CITY OF ALBUQUERQUE

August 10, 2023

Re: Playa Del Sur
99999 Miami Rd. NW
Traffic Circulation Layout
Engineer's Stamp XX-XX-XX (H11-D075)

PLAYA DEL SUR
COORS AND I40
SITE PLAN

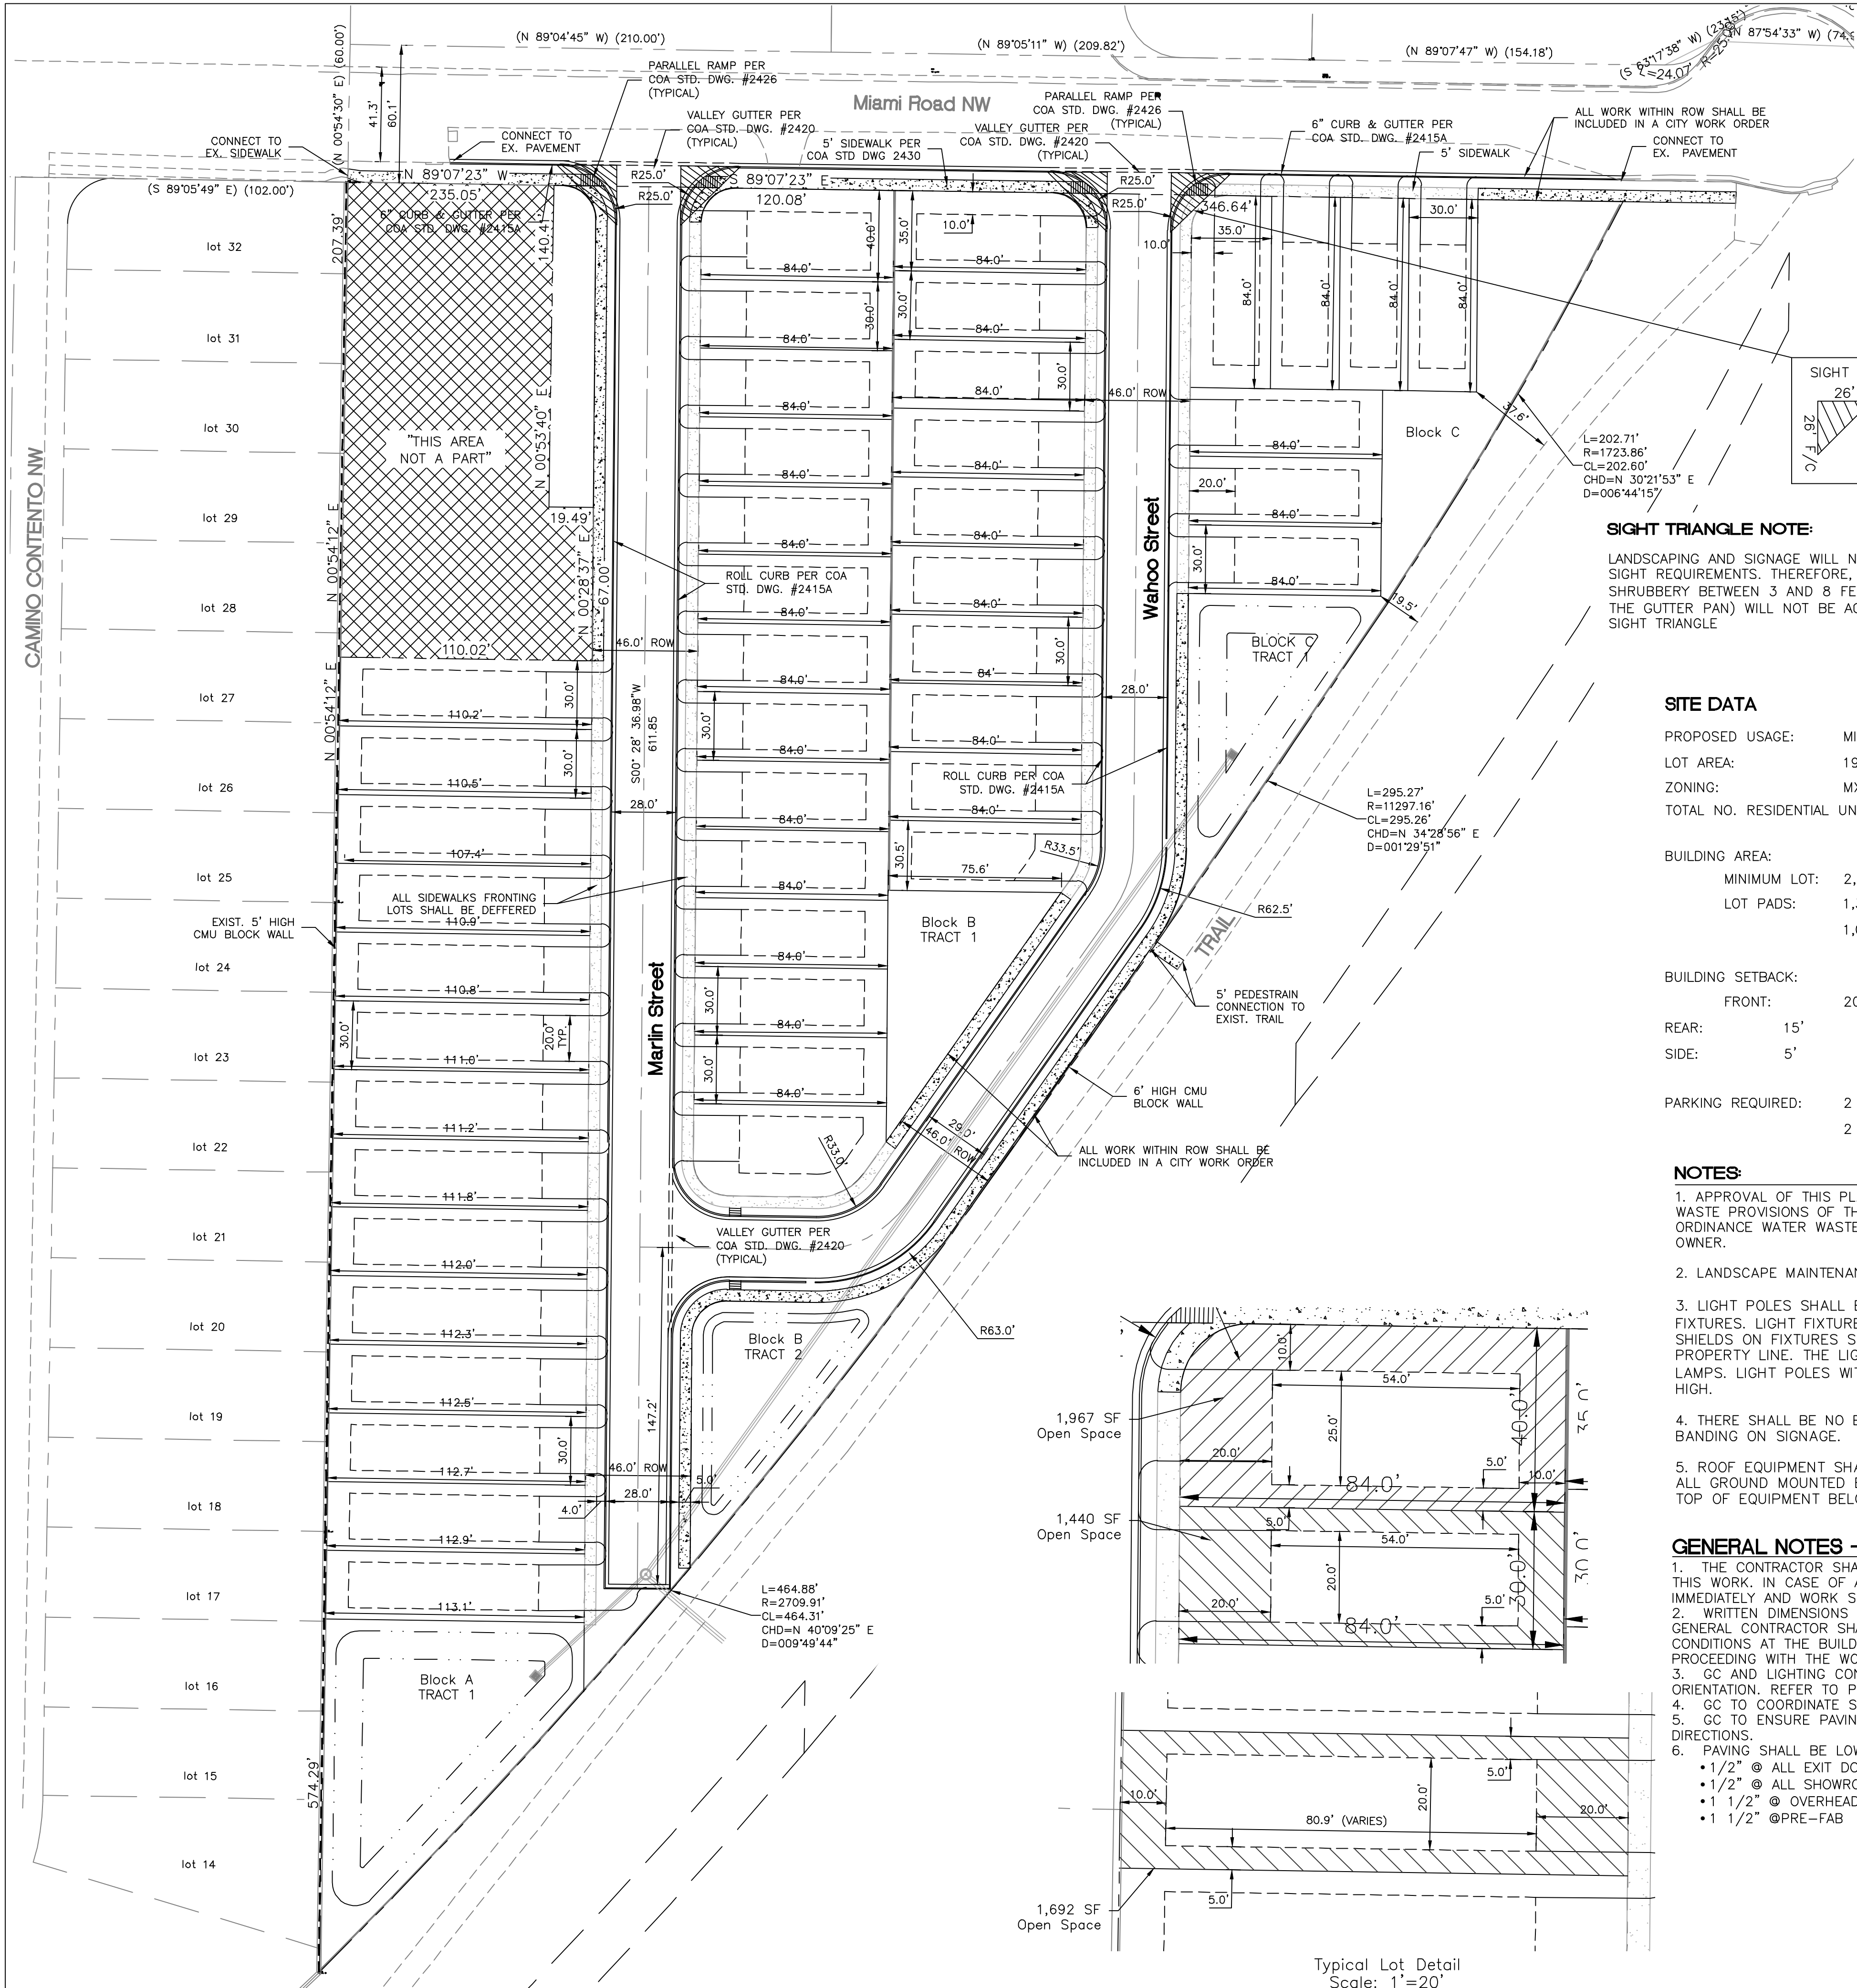
1. Show on the site plan the site accesses radiuses.
2. Engineer's stamped must be dated.
3. Show the clear sight triangle for both site acceses and add the following note to the plan:
"Landscaping and signage will not interfere with clear sight requirements. Therefore, signs, walls, trees, and shrubbery between 3 and 8 feet tall (as measured from the gutter pan) will not be acceptable in the clear sight triangle."

4. Provide notes showing what work is included and on the work order and the private work on site.
5. Work within the public right of way requires a work order with DRC approved plans.

6. Please add a note on the plan stating "All improvements located in the Right of Way must be included on the work order."
7. Traffic Studies: See the Traffic Impact Study (TIS) thresholds. In general, a minimum combination of 100 vehicles entering and exiting in the peak hour warrants a Traffic Impact Study. Visit with Traffic Engineer for determination, and fill out a TIS Form that states whether one is warranted. In some cases, a trip generation may be requested for determination (**Contact Matt Grush: mgrush@cabq.gov**).

8. Please provide a copy of Solid Waste and Fire Marshal approval.
9. Please show on the site plan the status for the driveway for the highlighted lot.
